# KITTTITAS COUNTY

### MEMORANDUM

**TO:** All Staff  
**FROM:** Public Works Plan Review Team  
**DATE:** January 5, 2026- UPDATE January 27,2026  
**SUBJECT:** BL-25-00024 Haberman-Tirey

RECORD OF SURVEY

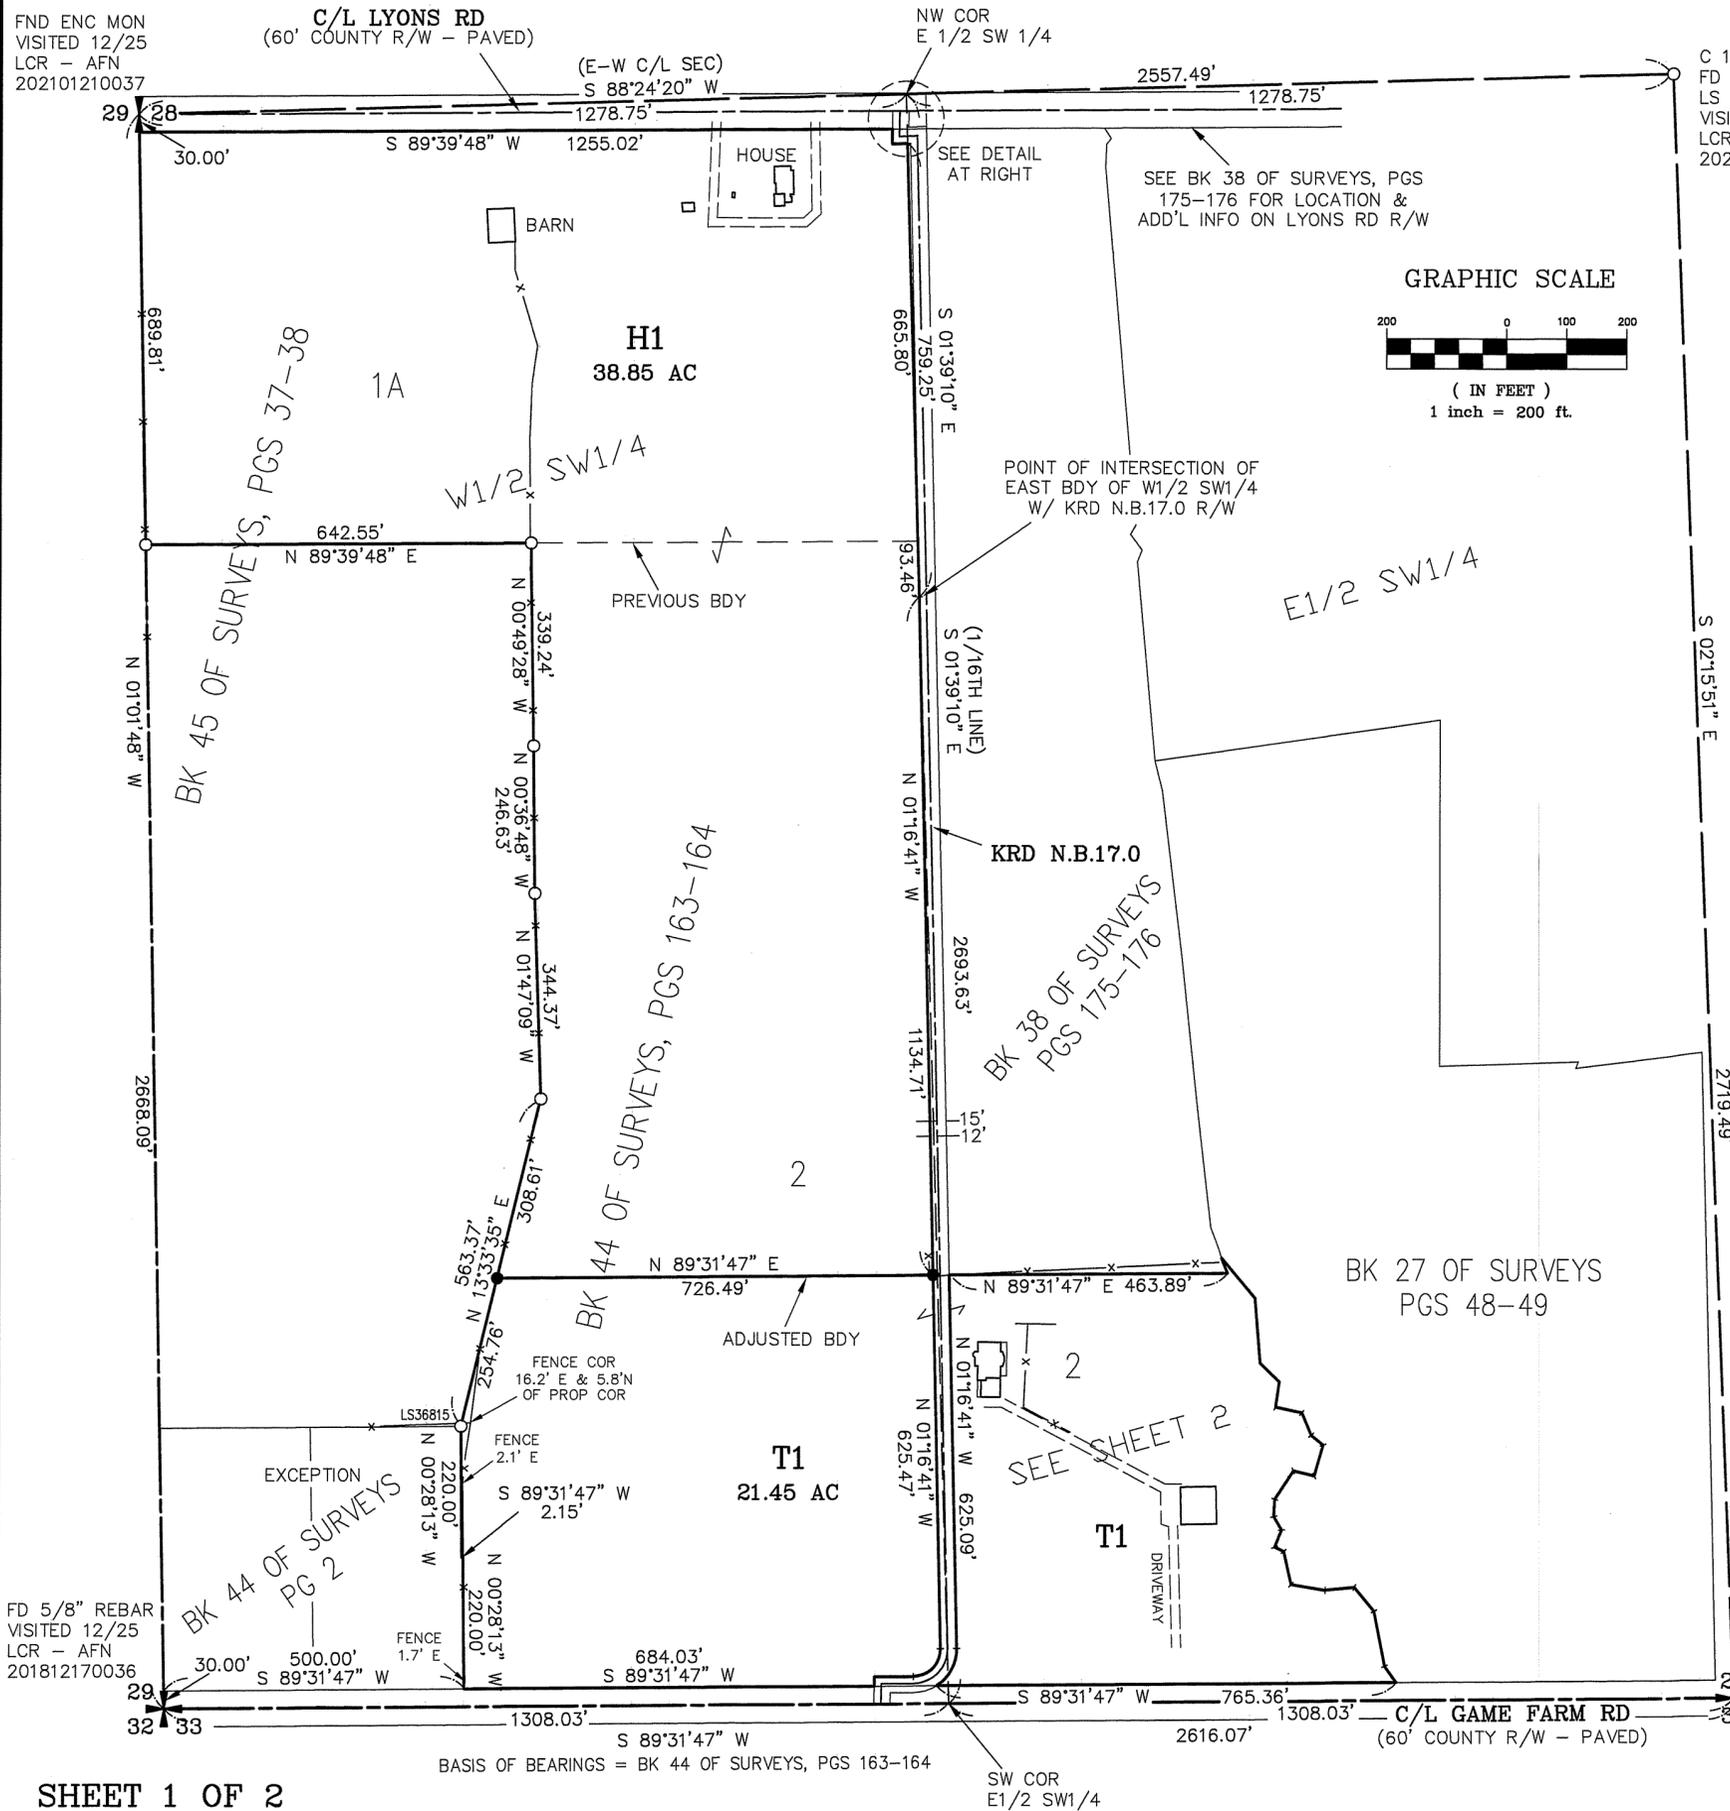
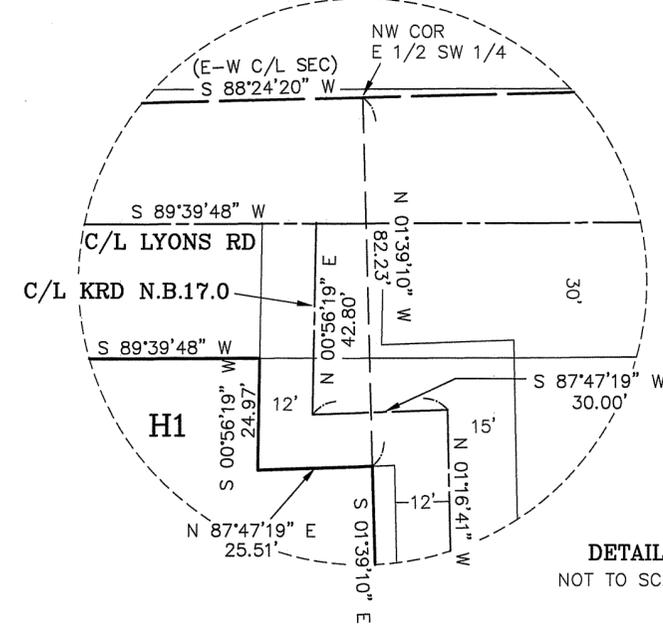
<b>SURVEY</b>	<p>As the application does not contain a survey map, comments are herein reserved until final review. (JT)</p> <p>UPDATE 01/27/2026  1. The aerial image for proposed Parcel H1 has a pond located near the south boundary. Please show this pond, or confirm it is no longer there. (JT)</p> <p>UPDATE 02/03/2026  The updated survey map addressed all prior survey comments.</p>
<b>TRANSPORTATION CONCURRENCY</b>	<p>No transportation concurrency requirement for this project. (RC)</p>
<b>FLOOD</b>	<p>A portion of parcel # 17648 is mapped within a FEMA identified special flood hazard area (1 percent annual chance flood zone). All development within the floodplain must be permitted through the floodplain development permit process and follow the regulations within KCC 14.08.</p> <p>While not required by KCC 14.08.220, it is highly encouraged that the floodplain boundaries are outlined on the face of the recorded survey. (SC)</p>
